RFI

RFI #: 80
Date: 3/20/2012
Job: EB-02 Keller Springs Lofts
Phone: 877-777-5115

Subject: Elevation conflict with floors

Drawing: 3.1, 3.2, 3.3, 3.4
Cost Impact: None
Spec Section:
Schedule Impact: None

DATE	08-05-2011	SHEET NUMBER	3.1
PROJECT	11129

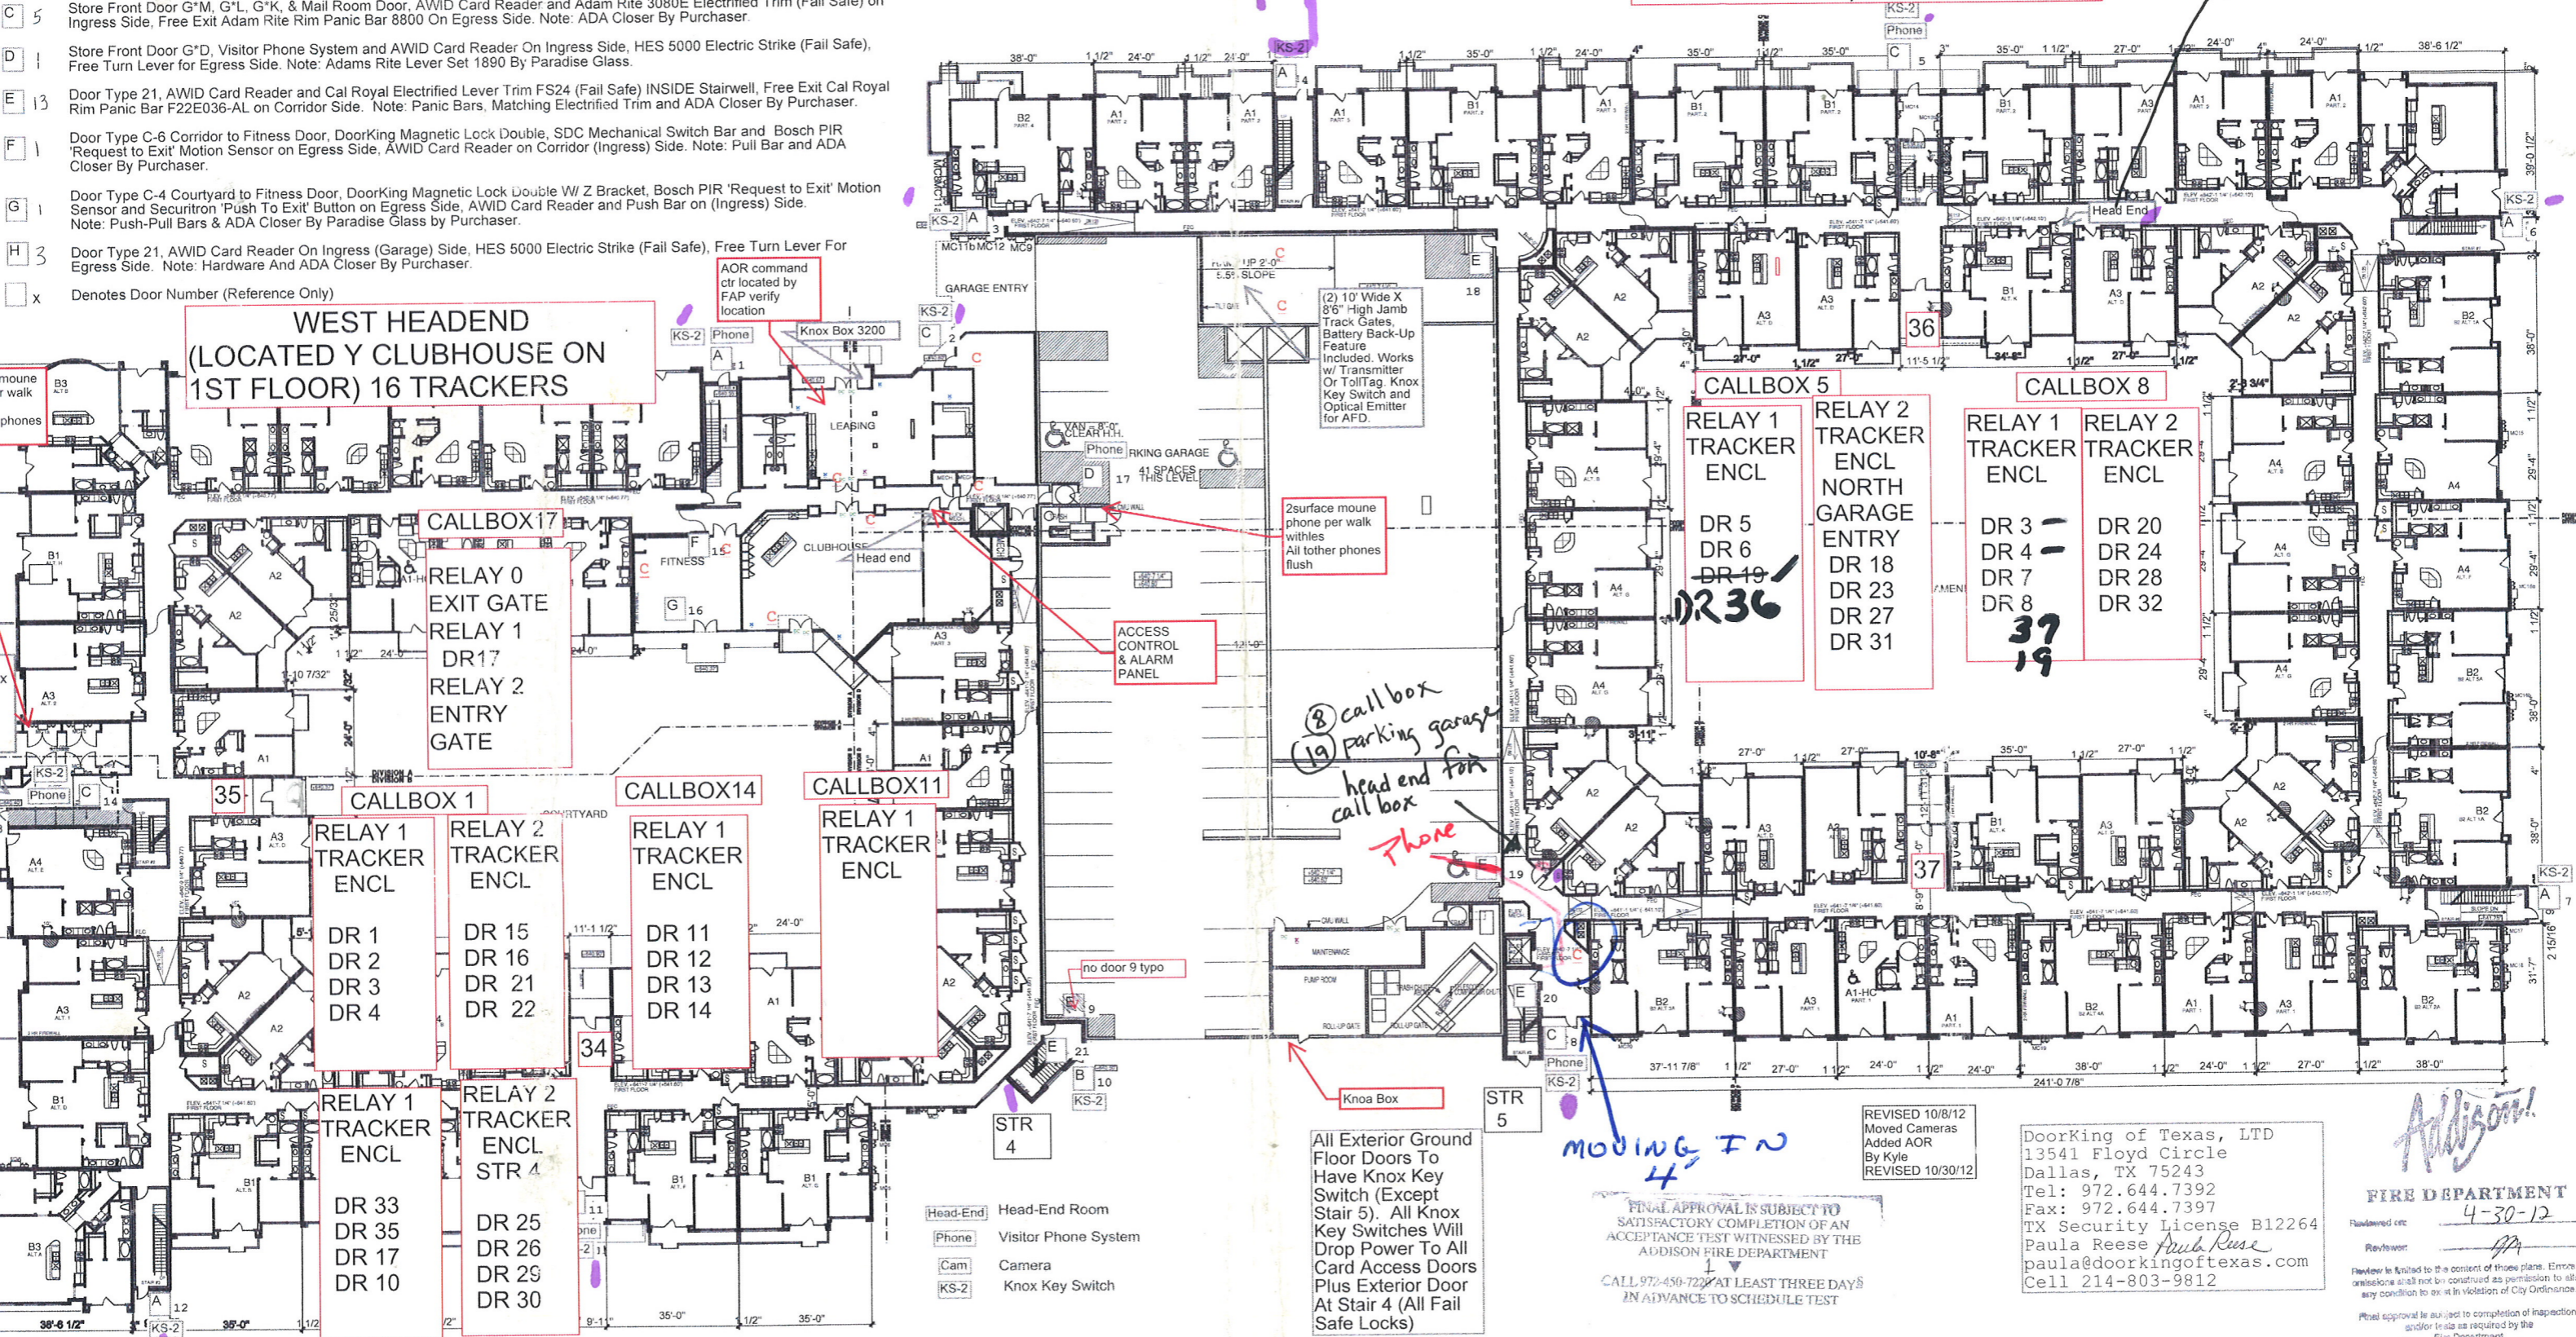
Thank you for addressing RFI #48. Your answer to #48 has us installing an additional 1x to the bottom plate to achieve specified elevations at 2nd 3rd and 4th floors around the parking garage. We do agree with adding the 1x to 2nd and 3rd floor bottom plates, but we think it should be to the entire 2nd and 3rd floors. The problem that we resolved around the garage is still present at the other stairwells. Here is a list of potential problems with installing the 1x to only parts of the floor

- 1 we will have step downs in the corridor ceilings
- 2 we will still have elevation problems at stairwell #s 1-2-3-5-7-8
- 3 floor plate differences at exterior elevations
- 4 the ramping of the floors (that you have addressed)
- 5 we will have to add a 1x to top of 4th to all areas not raised or field cut all of the studs in your shaded area to achieve proper roof truss bearing.

In summary we think that we should install the 1x to all of 2nd and 3rd floor bottom plates. Erik this was previously discussed with the Project Manager David Gallagher, the Project Super Brian Peterson and with you and agreed upon by all parties.

Response: BGO agrees and has no exception to this change.
